SUBJECT: WDFW COMMENTS SE-24-00023 Thayer

Thank you for the opportunity to comment on SE-24-00023 regarding the Thayer Riprap Site Soil Import project application. The Washington Department of Fish and Wildlife (WDFW) has reviewed the application and supporting documents on file. Our comments are regarding the project's impact on Fish and Wildlife Habitat Conservation Areas, such as priority habitats and species (PHS), particularly shrubsteppe habitat.

Critical Areas Map

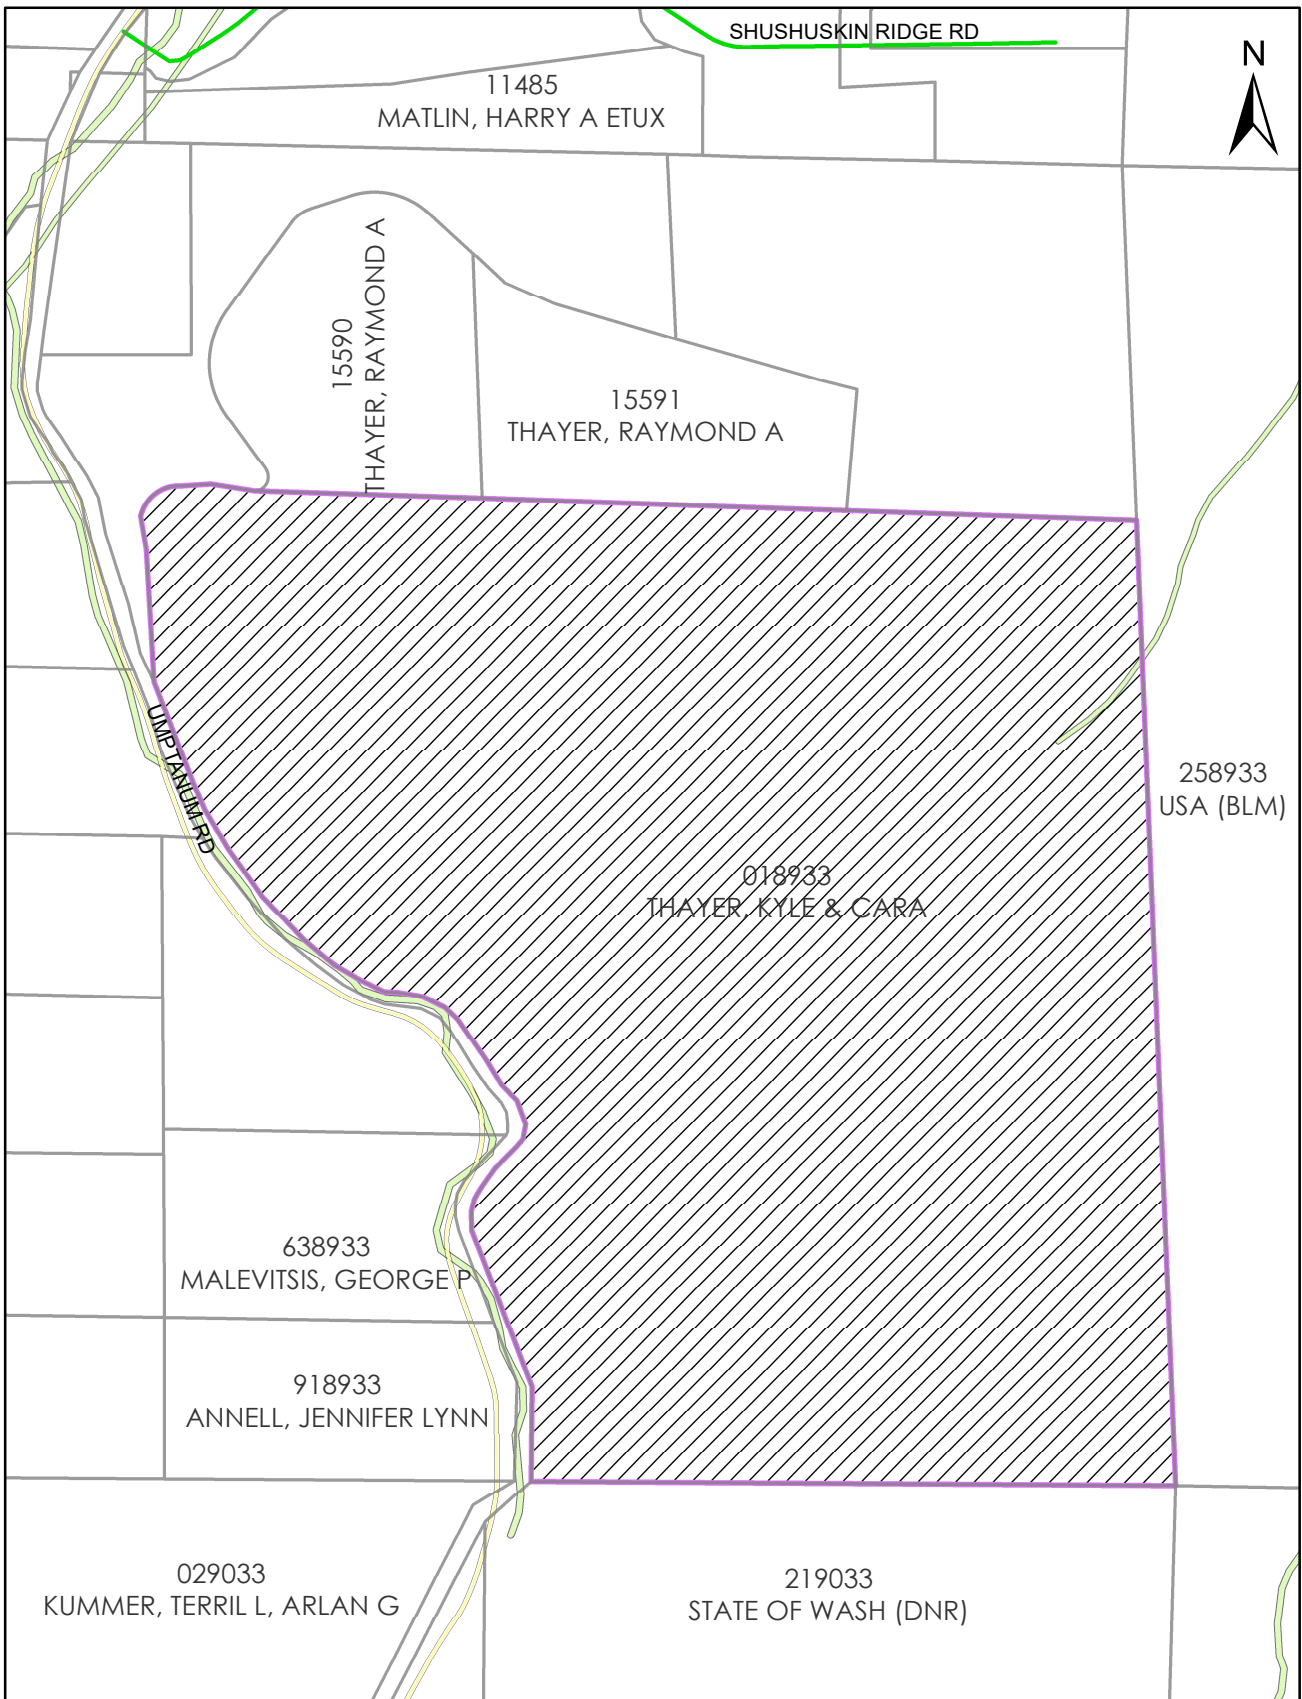
The project area contains shrubsteppe habitat and is mapped as Manastash Ridge Mule Deer Winter Range, Manastash Ridge Elk Winter Range, and Umtanum Bighorn Sheep Annual Range, all of which are designated Fish and Wildlife Habitat Conservation Areas under Kittitas County's Critical Areas Ordinance (Chapter 17A.04).

The covering of shrubsteppe habitat with topsoil will negatively impact wildlife and habitat. To ensure no net loss, we recommend avoiding and minimizing shrubsteppe impacts as much as possible by utilizing already disturbed areas on site to the maximum extent, thus limiting the amount of new disturbance.

Any new disturbance should provide compensatory mitigation consistent with WDFW's PHS guidelines, 1:1 if the shrubsteppe habitat will be restored after the topsoil is gone and the proposed project has concluded, or 2:1 if the habitat will not be restored. To further understand shrubsteppe impacts, potential for mitigation and restoration, WDFW requests a site visit with the applicant and the County. A mitigation, monitoring and restoration plan should be prepared in consultation with WDFW as a condition of approval.
